From: Laura Gibbons
Sent: 27 August 2019 13:38
To: Planning.Responses <Planning.Responses@arun.gov.uk>
Cc: Amber Willard <Amber.Willard@arun.gov.uk>
Subject: RE: Planning Consultation on: AL/62/19/PL

Engineers Comments Regarding Surface Water Drainage

APPLICATION NO: AL/62/19/PL

Site Address: Land Rear of Sundown Littleheath Road Aldingbourne BN18 0SR

Image of initial test taken on site within a 300 x 300 test hole at 800mm depth.

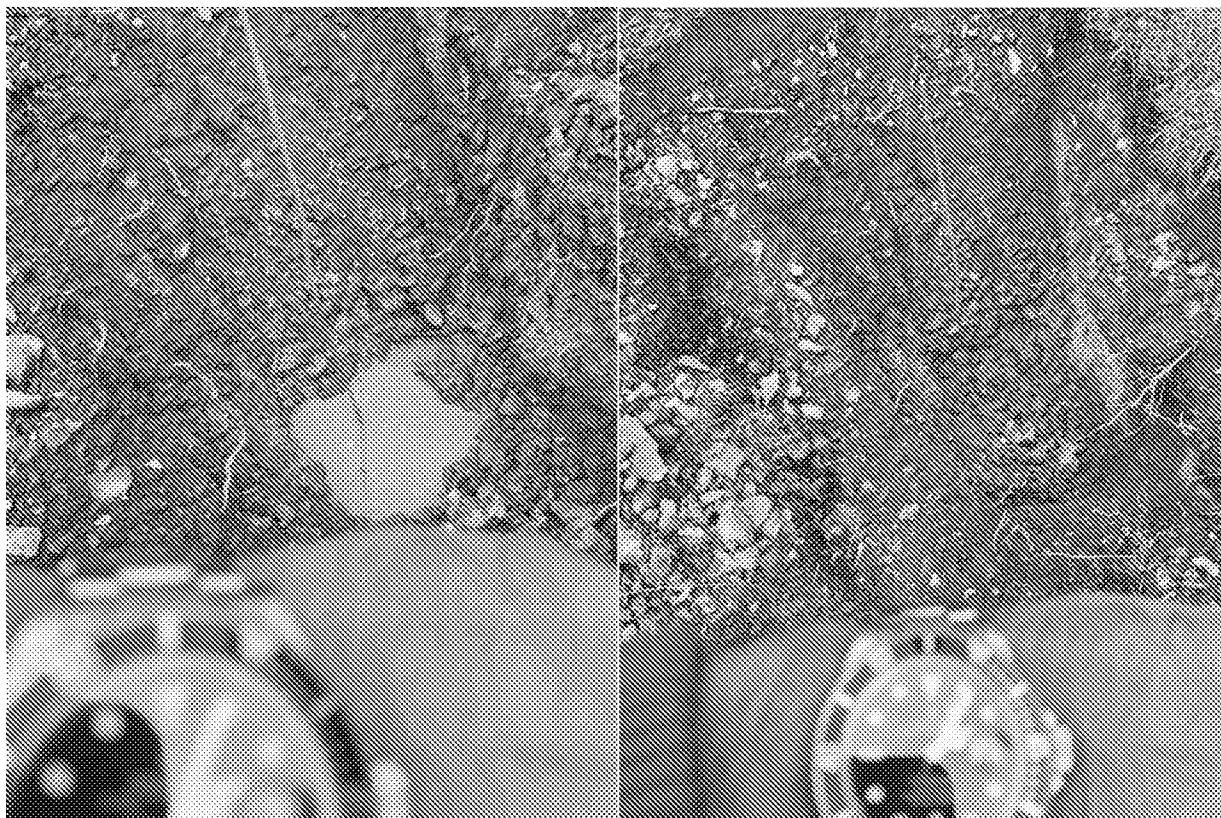
The application is within the Lidsey Catchment. Some infiltration testing has been completed, but this was not completed to BRE365 and the date of this testing is unknown. Full BRE365 compliant winter infiltration testing and winter groundwater monitoring must be completed. If you are minded to approve this application please apply the following condition:

“Development shall not commence, other than works of site survey and investigation, until full details of the proposed surface water drainage scheme have been submitted to and approved in writing by the Local Planning Authority. The design should follow the hierarchy of preference for different types of surface water drainage disposal systems as set out in Approved Document H of the Building Regulations, and the recommendations of the SuDS Manual produced by CIRIA. Winter groundwater monitoring to establish highest annual ground water levels and winter Percolation testing to BRE 365, or similar approved, will be required to support the design of any Infiltration drainage. No building / No part of the extended building shall be occupied until the complete surface water drainage system serving the property has been implemented in accordance with the agreed details and the details so agreed shall be maintained in good working order in perpetuity.”

“Infiltration rates for soakage structures are to be based on percolation tests undertaken in the winter period and at the location and depth of the proposed structures. The percolation tests must be carried out in accordance with BRE365, CIRIA R156 or a similar approved method and cater for the 1 in 10 year storm between the invert of the entry pipe to the soakaway, and the base of the structure. It must also have provision to ensure that there is capacity in the system to contain below ground level the 1 in 100 year event plus 40% on stored volumes, as an allowance for climate change. Adequate freeboard must be provided between the base of the soakaway structure and the highest recorded annual groundwater level identified in that location. Any SuDS or soakaway design must include adequate groundwater monitoring data to determine the highest winter groundwater table in support of the design. The applicant is advised to discuss the extent of groundwater monitoring with the Council's Engineers.
